CITY OF  
Albuquerque  
Public Works Department

February 14, 1997

RE: TAPIA LAW OFFICE (J14-D117). GRADING AND DRAINAGE PLAN  
SUBMITTAL FOR PRELIMINARY PLAT, SITE DEVELOPMENT (FOR BUILDING  
PERMIT), AND FINAL PLAT APPROVAL. ENGINEER'S STAMP DATED  
FEBRUARY 4, 1997.

GRADING AND DRAINAGE PLAN

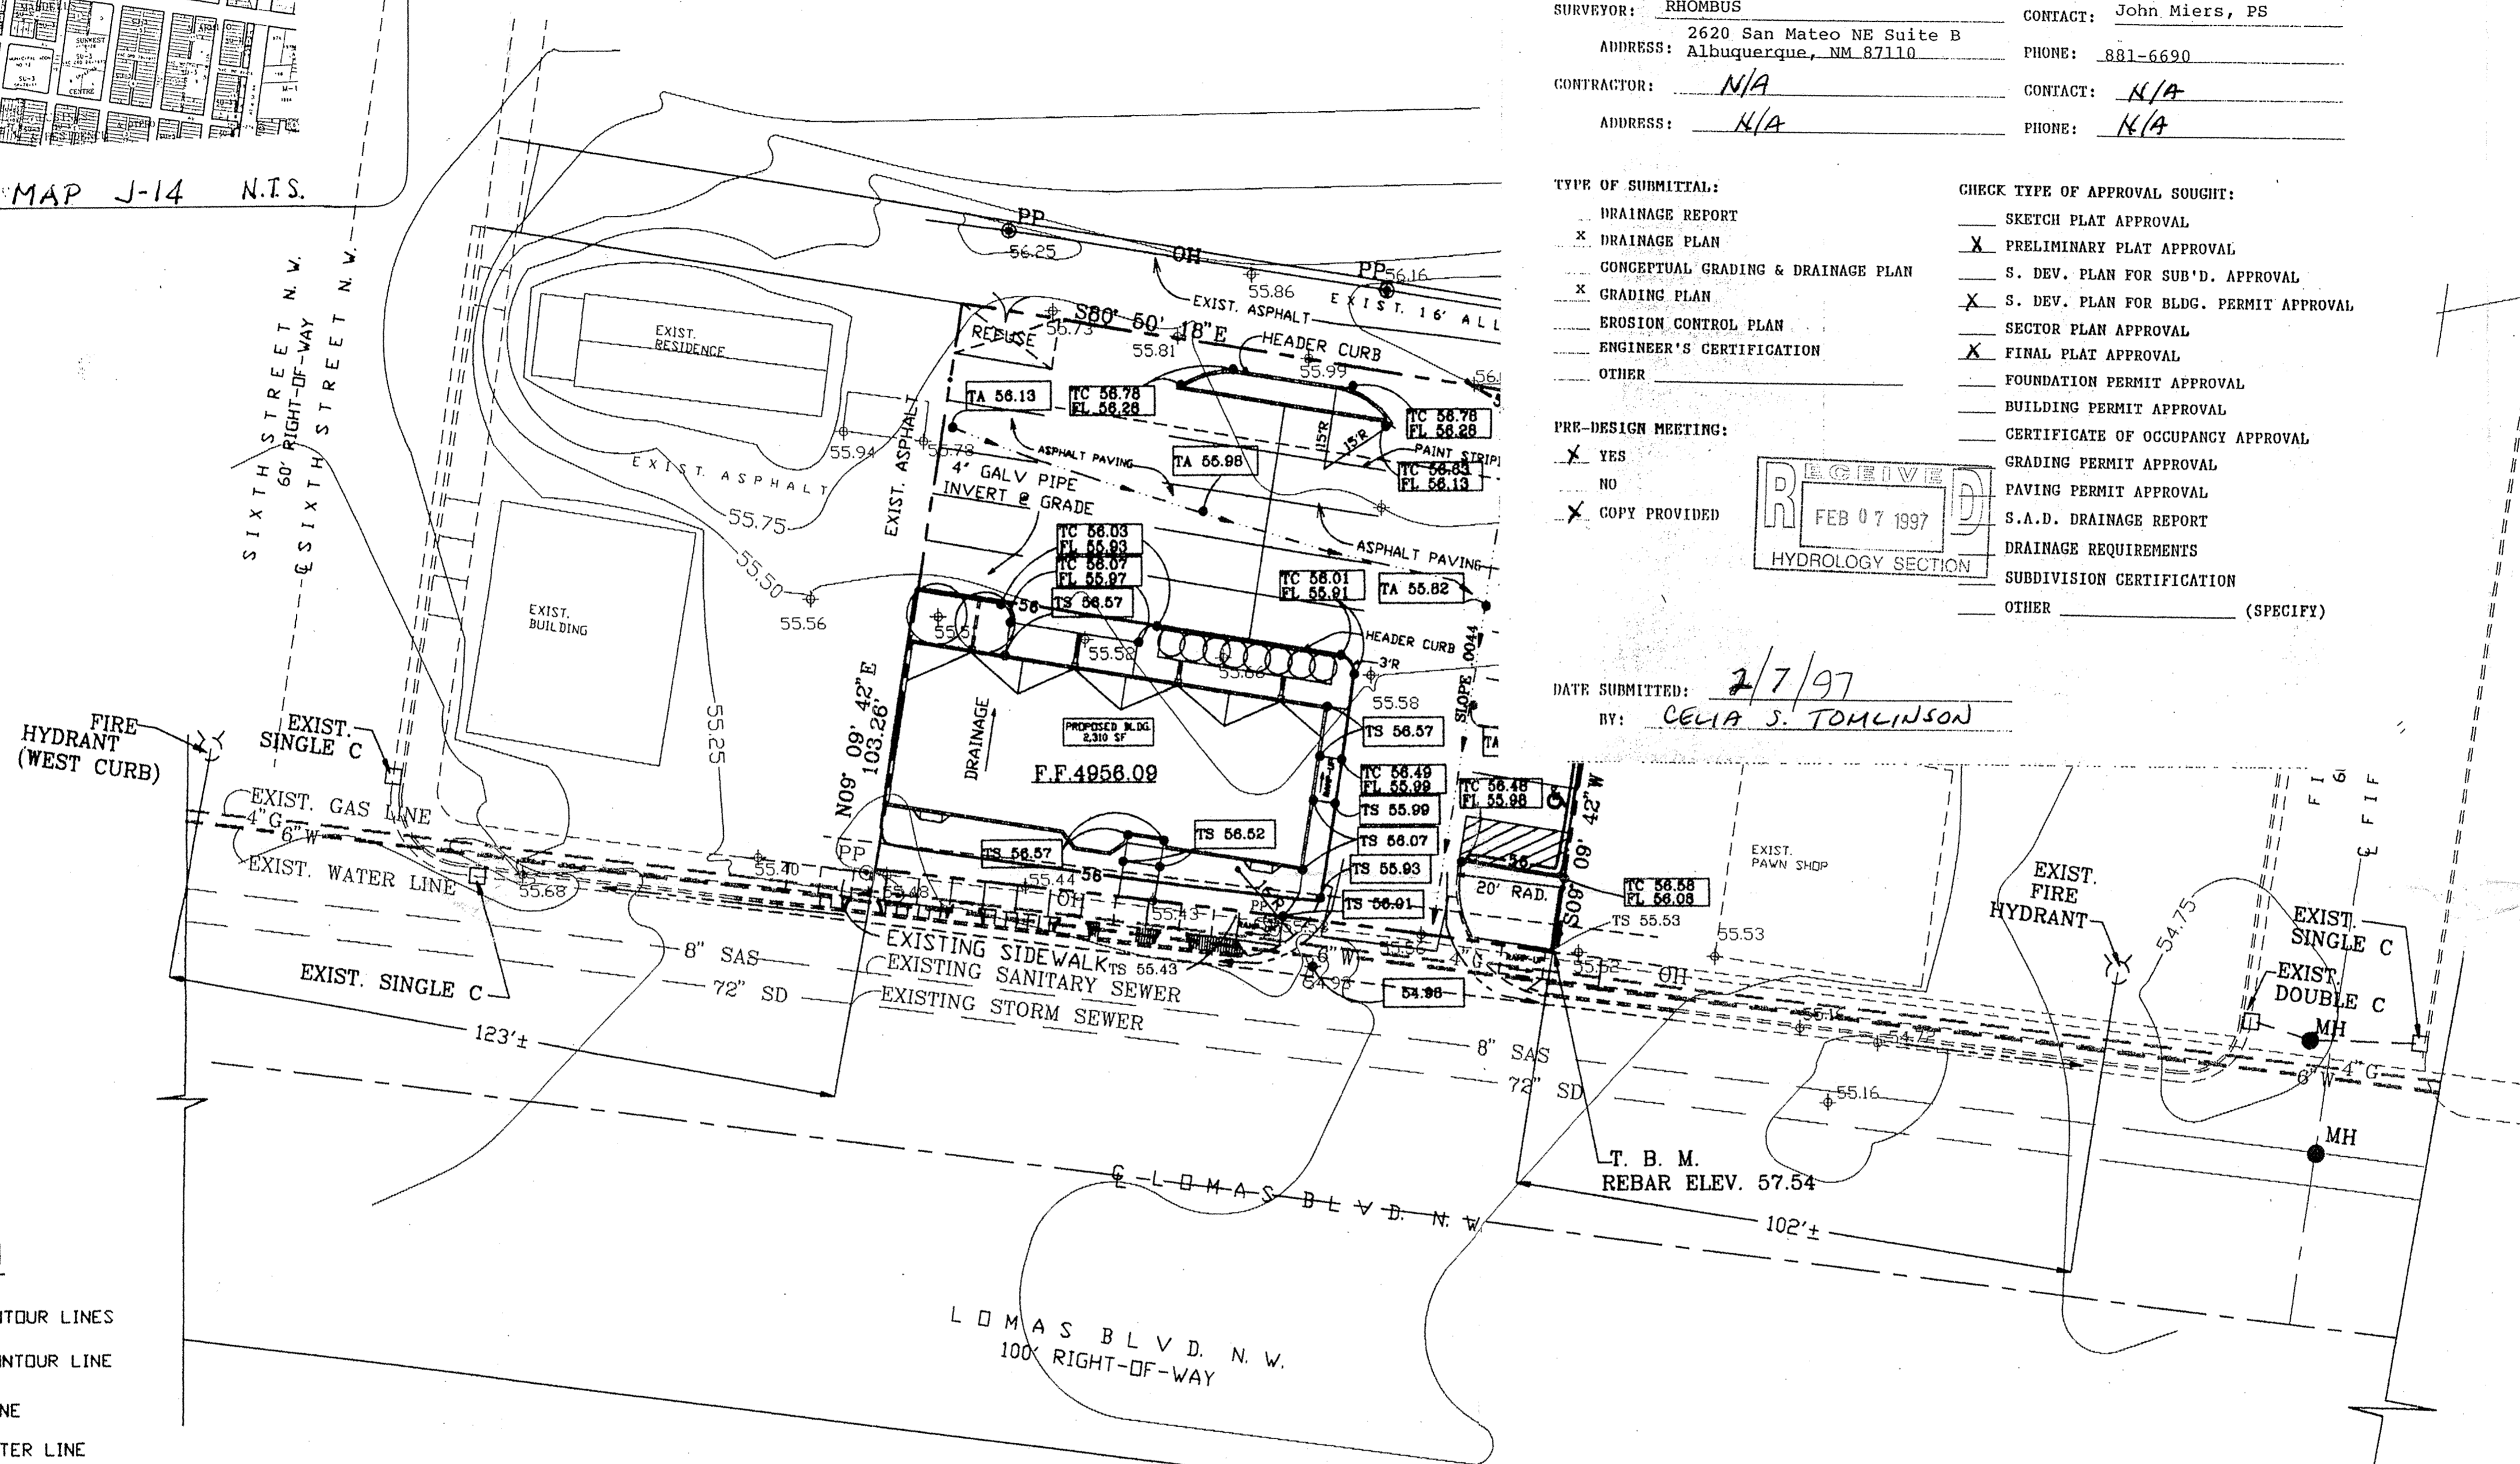
- DOE* 1. You will be required to pond the 0.55 cfs increase in flow  
per the pre-design conference requirements.
- SHOWN* 2. Indicate the required 1-foot water block at the driveway.
- ATTACHED* 3. Provide a copy of the proposed plat and a DRB number.
